## **Phase 3 – Catalyst, Bicester** **Technical Note – LLFA / CDC Drainage Response**

This technical note has been produced as an addendum to Application No: 22/03693/DISC relating to discharge of Condition 18 (SW Drainage). "Phase 3" (Units 10-13) is to be completed in one single sub-phase, completing the 3<sup>rd</sup> and final phase of development at the wider Catalyst development. Please find below Bailey Johnson Hayes responses to consultee comments received to date.

Scale: 1:500 @A1 Drawing Number: S1358-DD02 C
Date: 01.07.19
Drawn: JNG

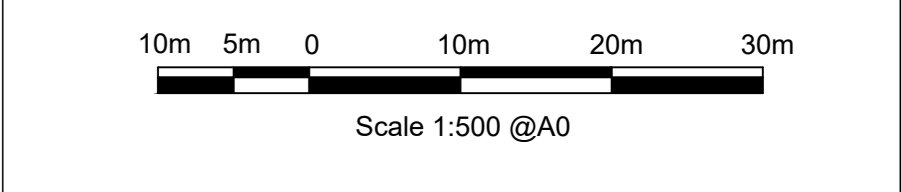
1. Provide pipe numbering on the drainage plan which should read in line with the calculations produced.

Drawings No. S1358-PH3-05A, 07A and 9A have been updated to provide MircoDrainage calculation pipe numbers and lengths as requested. Please note all pipe number can be found on drawing no. S1358-DD02 Rev C which is appended to the Catalyst Bicester SW Drainage calculations package revision 3.

Drawing Number: S1358-DD05 A

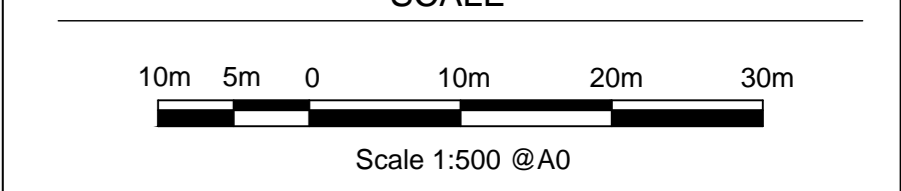
5. Provide flood exceedance plan with flood arrows demonstrating that all surface water will be kept away from structures and within the site boundary.

Please find submitted S1358-DD05 Rev A. Note this was also appended to the Catalyst Bicester SW Drainage calculations package revision 3.

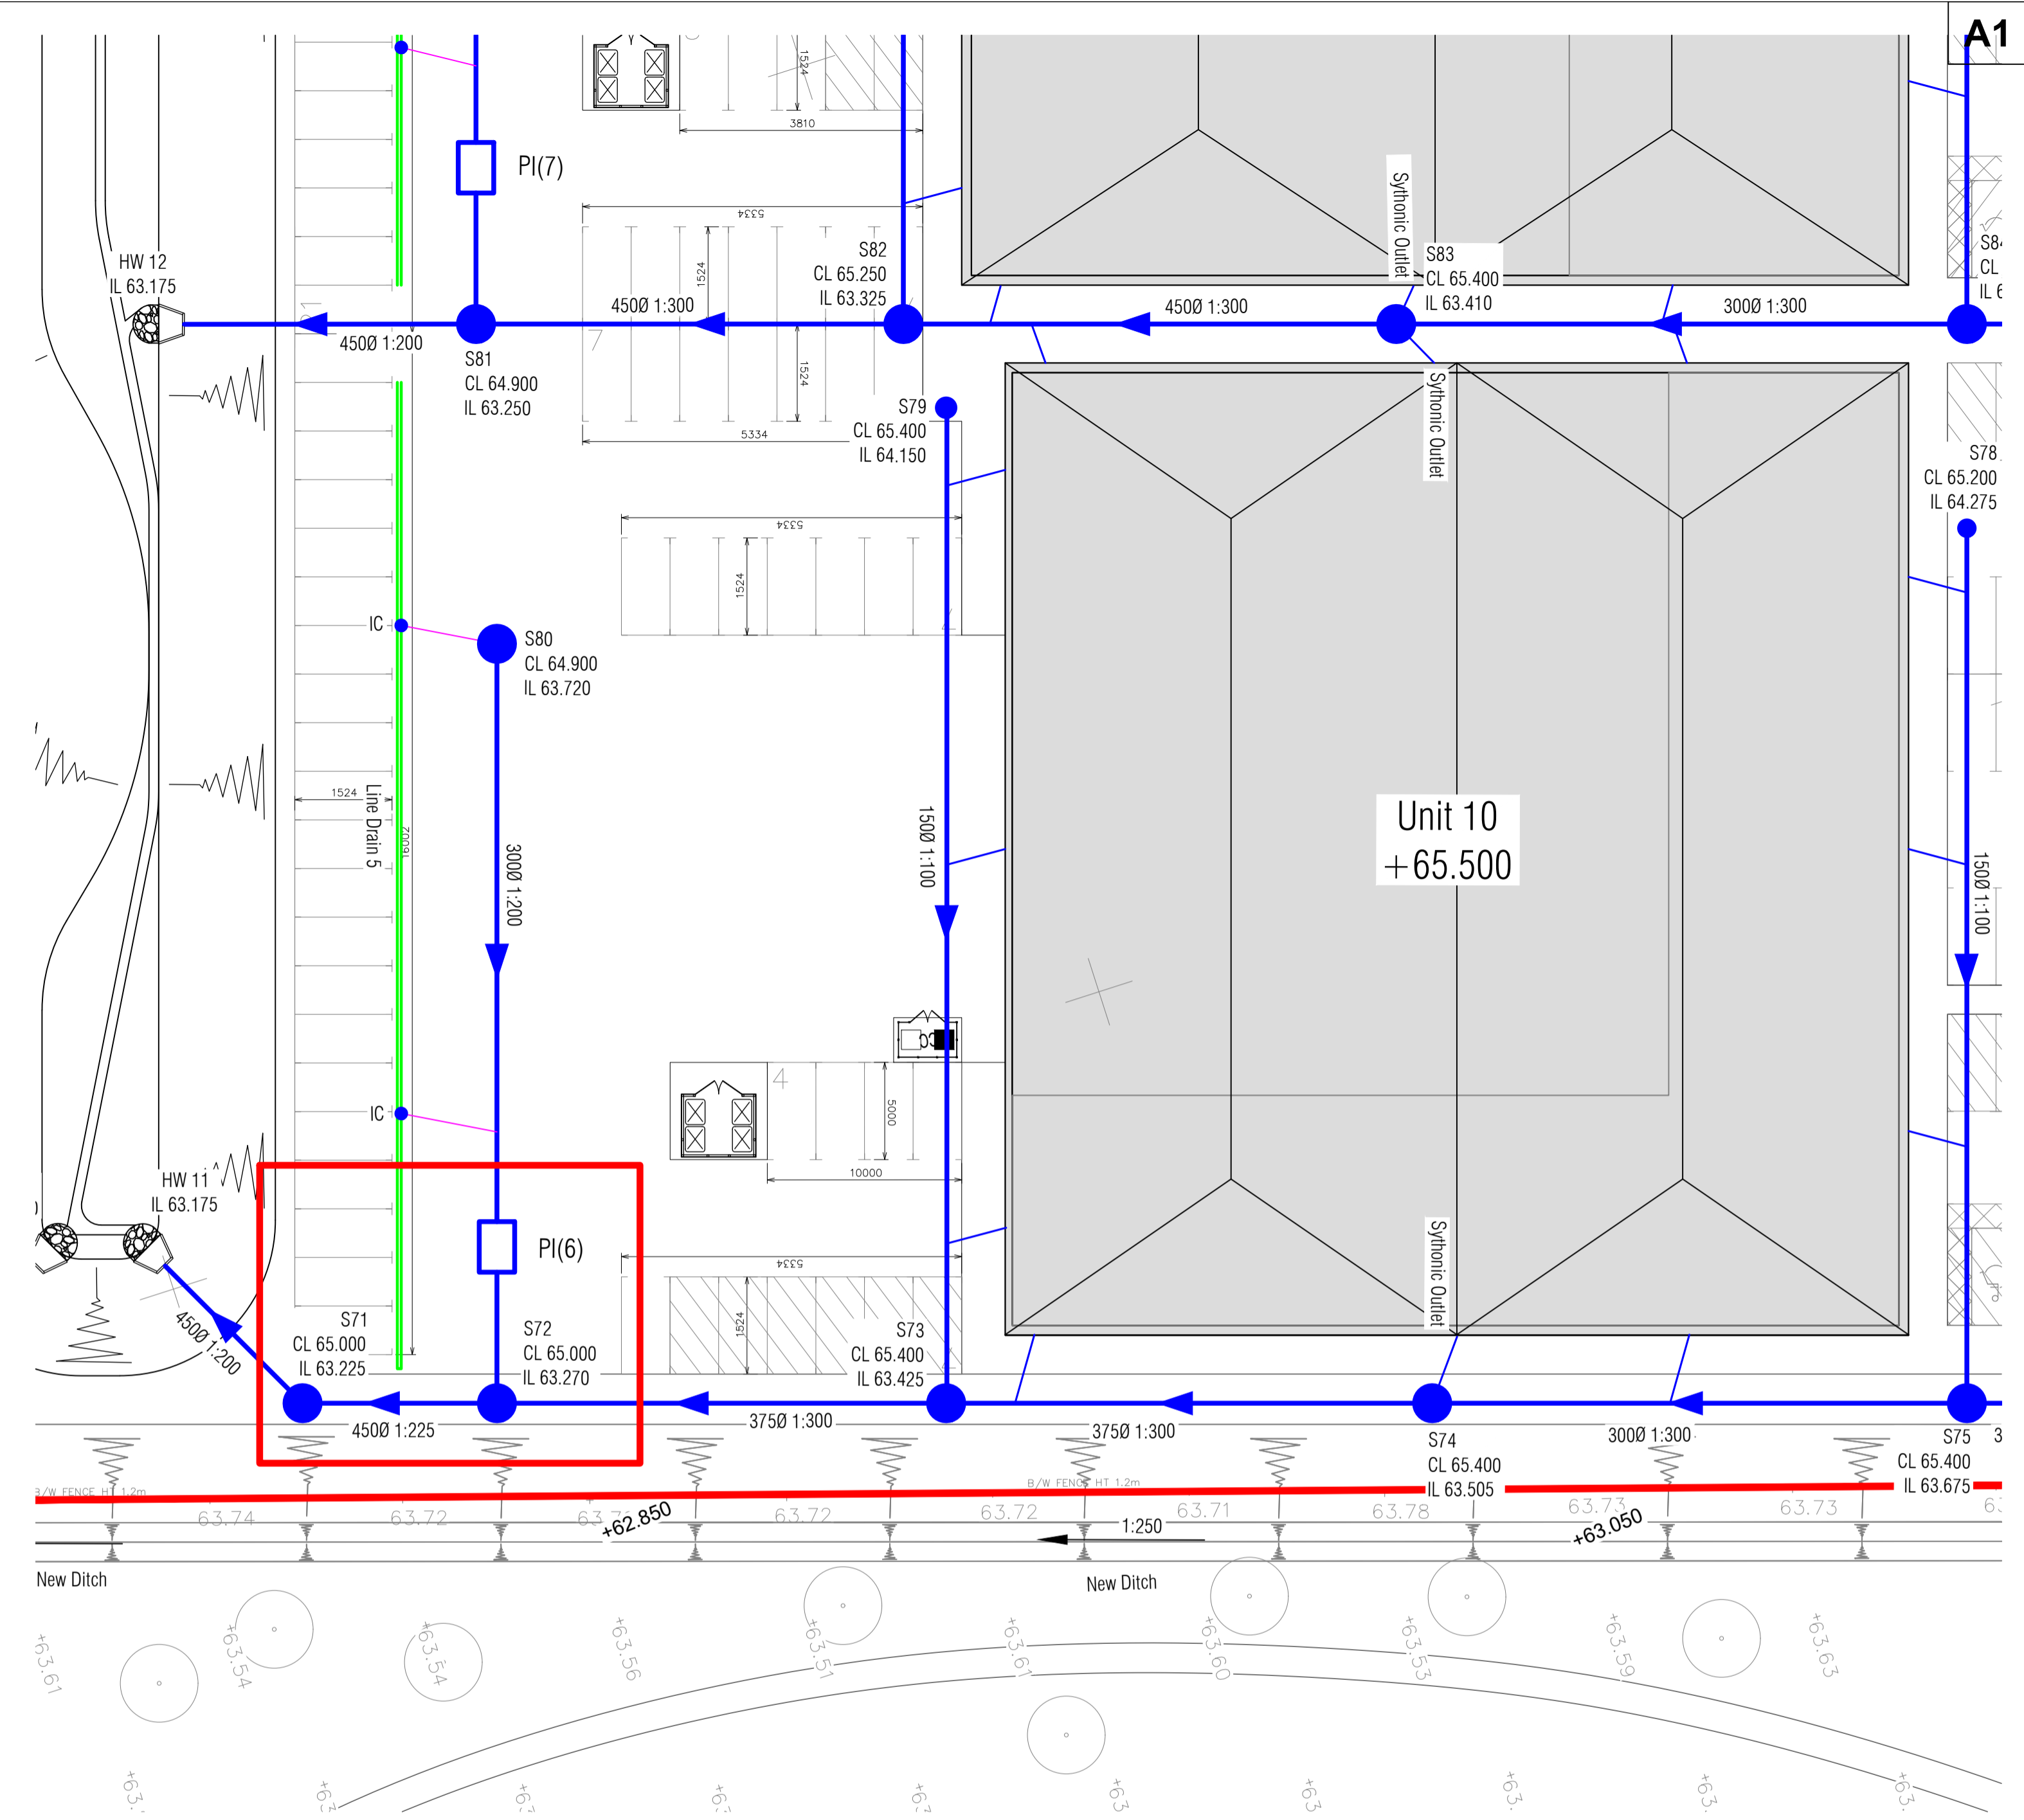
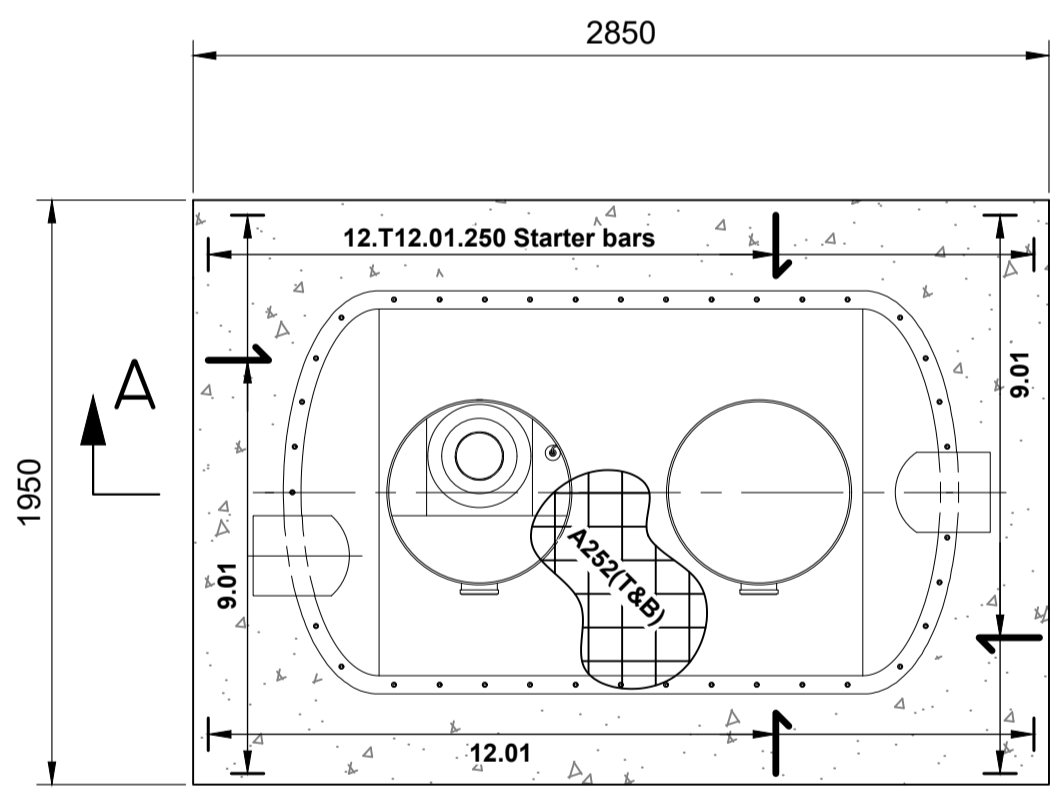
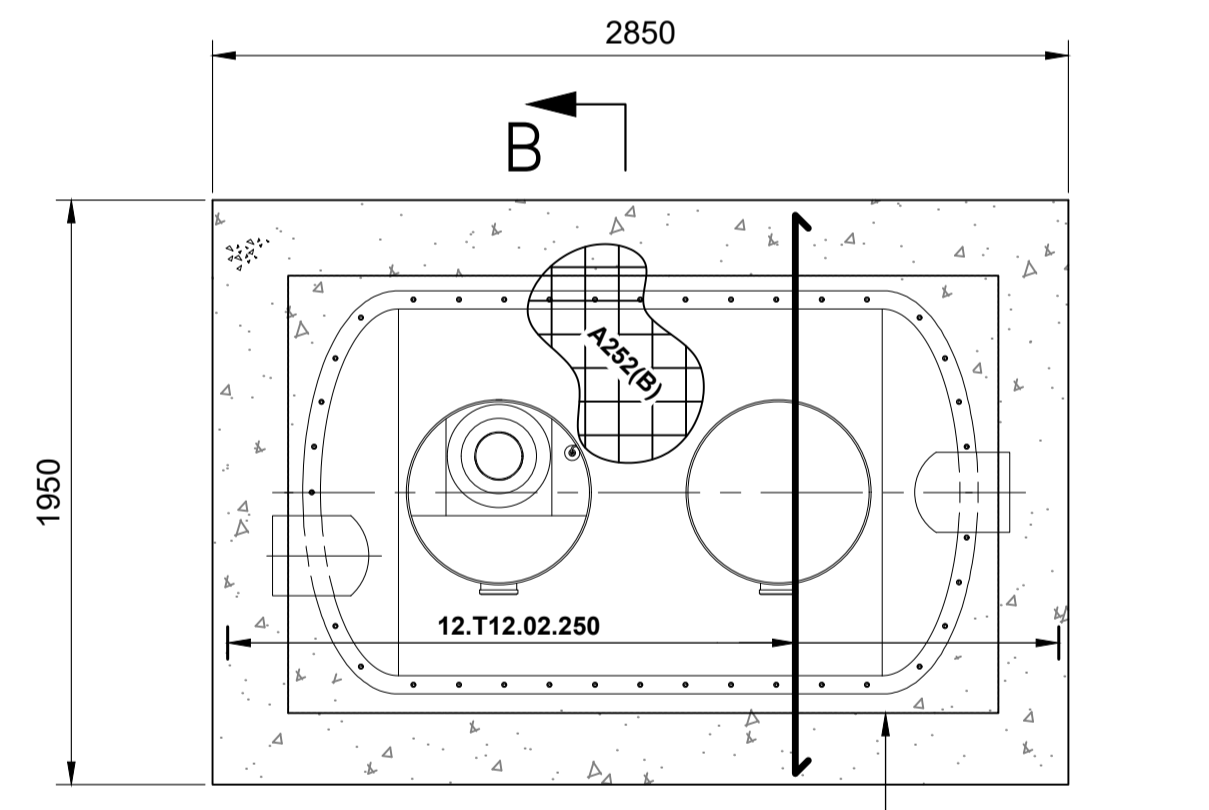
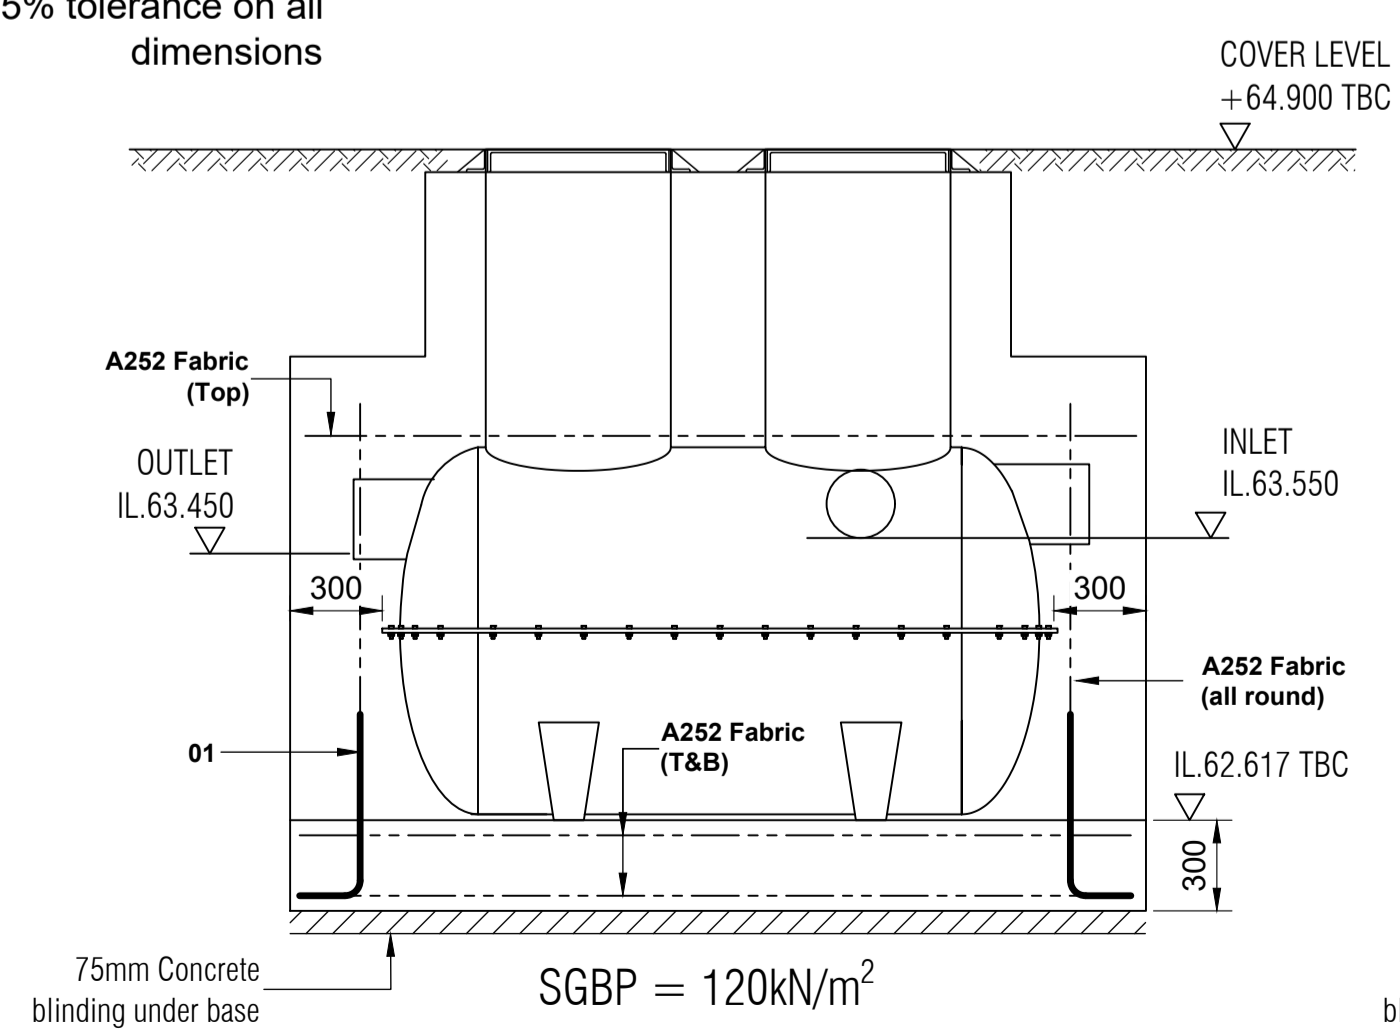
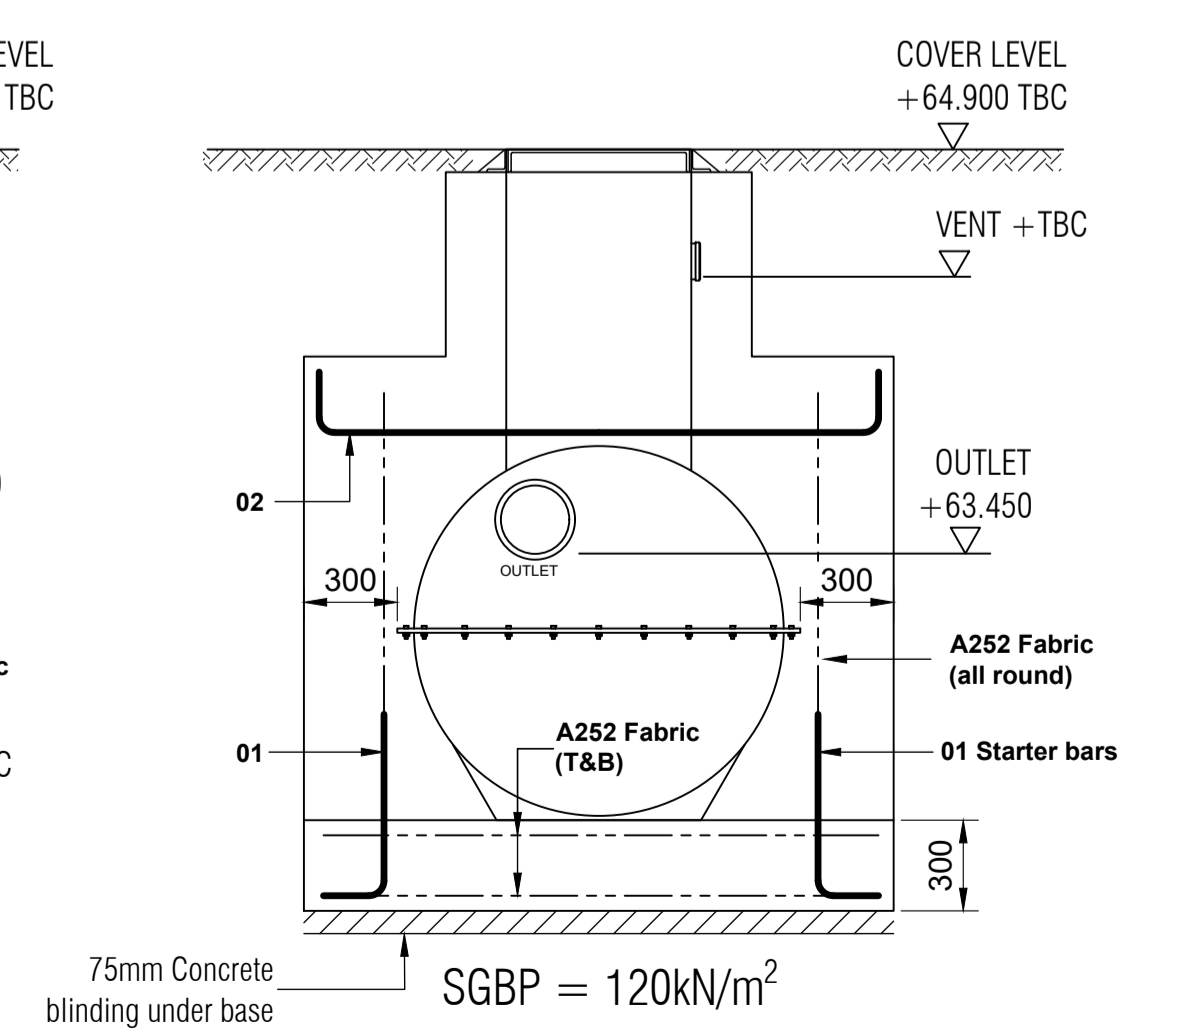
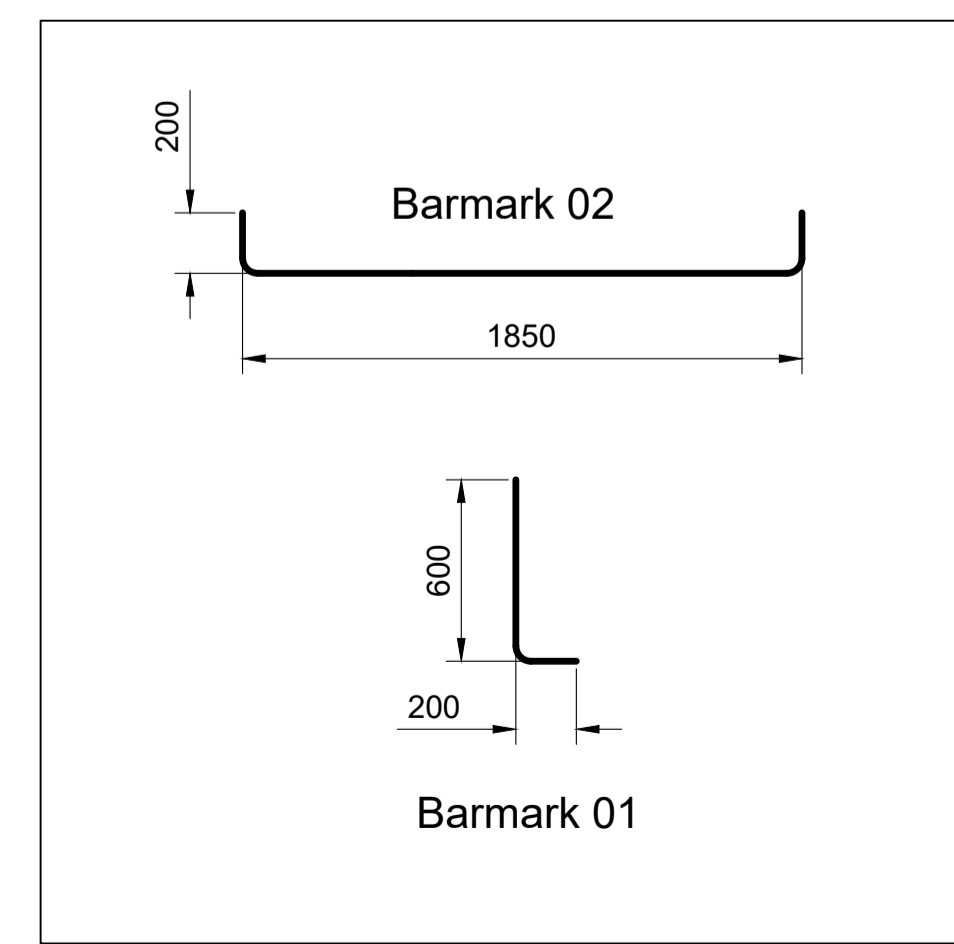
2. Provide SuDS construction details drawings.

New Drawings No. S1358-PH3-14, 15, 16, 17, 18 & 19 are now submitted to provide full details of the Attenuation Basin 1, Petrol Interceptors 6-8, Permeable Paving, Hydro-brake outlet details and flood compensation control details.
